Application for Planning Permission

Development: Demolition of 3 No. garages & erection of a four-room house of multiple occupation with shared facilities & parking for 3 cars (resubmission of LU/125/19/PL). This site is in CIL Zone 4 & is not CIL Liab as other development.

Location: 54 Arundel Road Littlehampton BN17 7DD

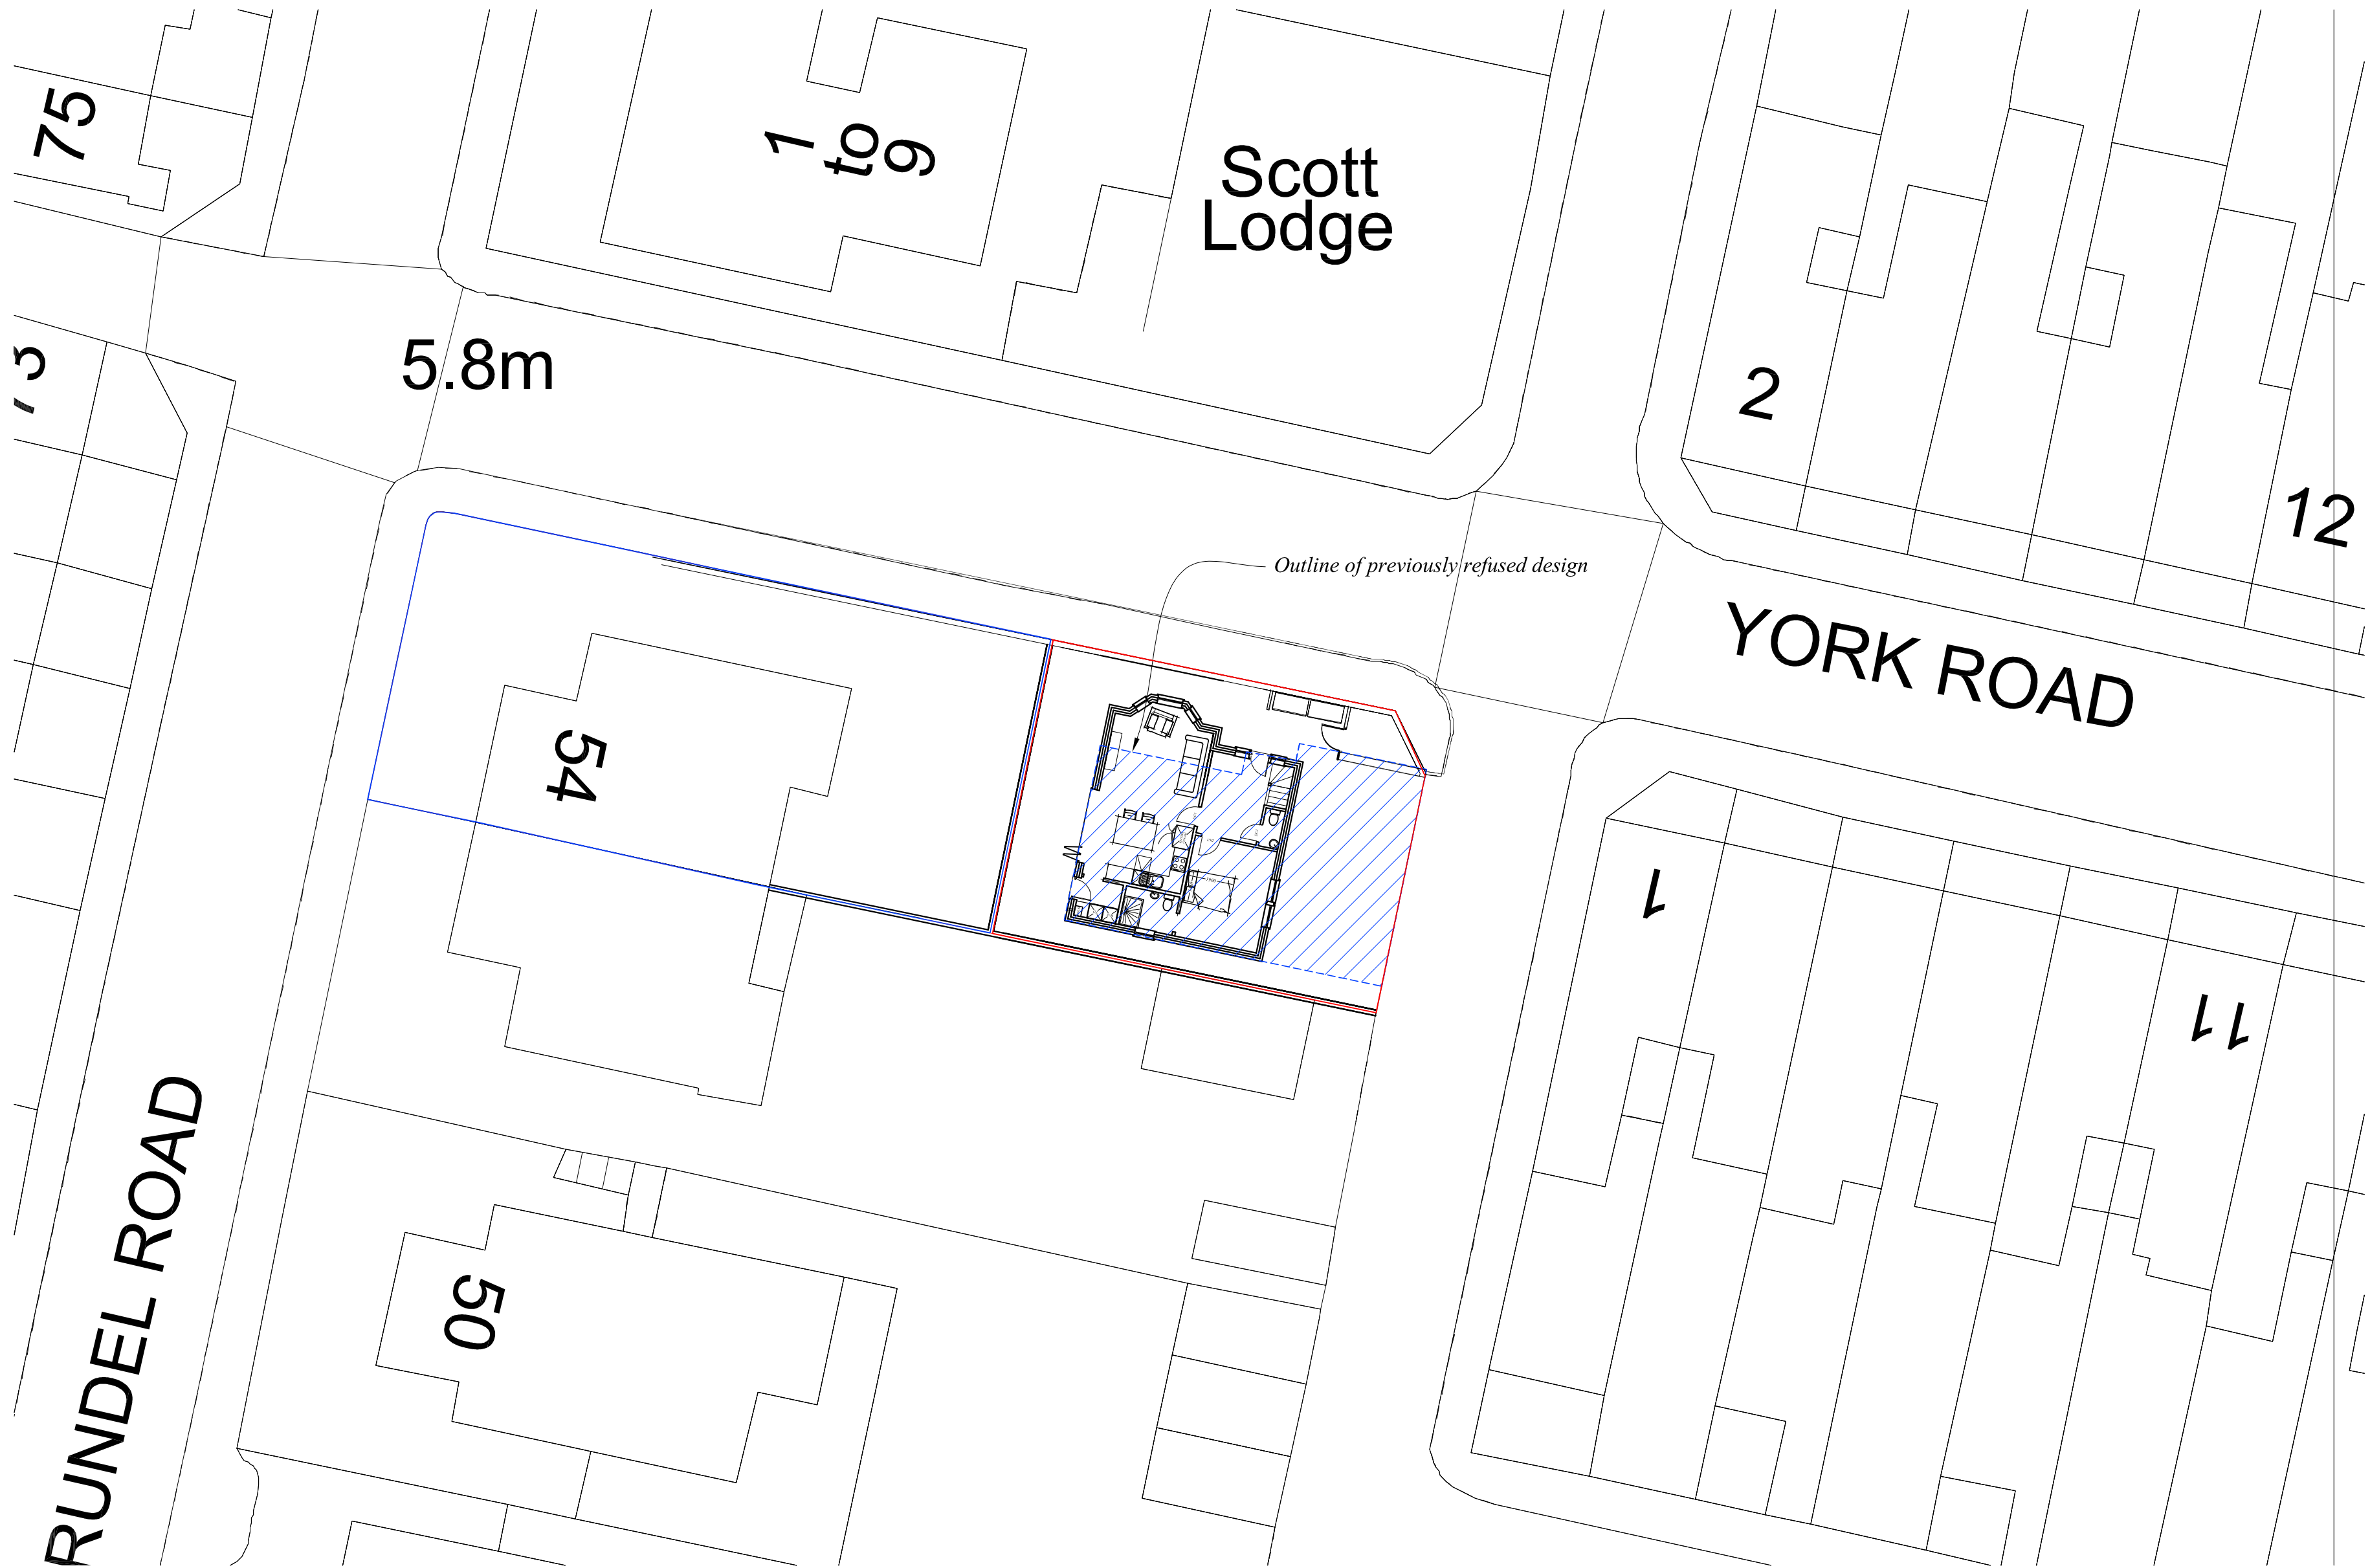
Please only red edge the application site and blue edge any land adjoining the application site that is owned/in control of by the applicant.

On the proposed site plan, please provide measurements from the proposal to the site boundaries.

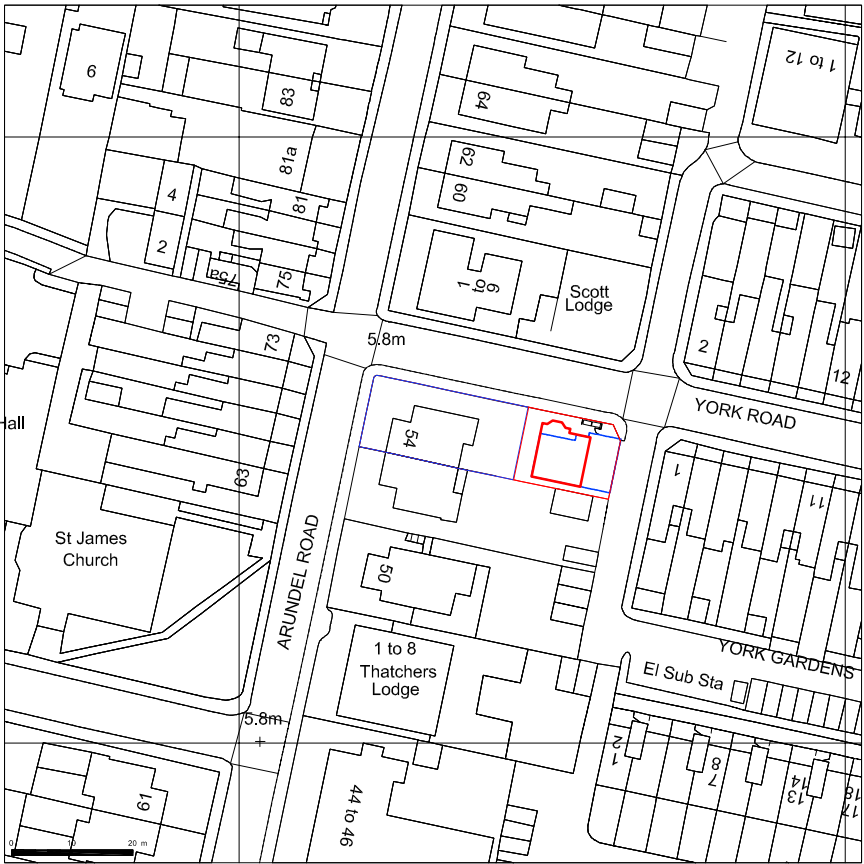
Please only red edge the application site and blue edge any land adjoining the application site in control/owned by the applicant.
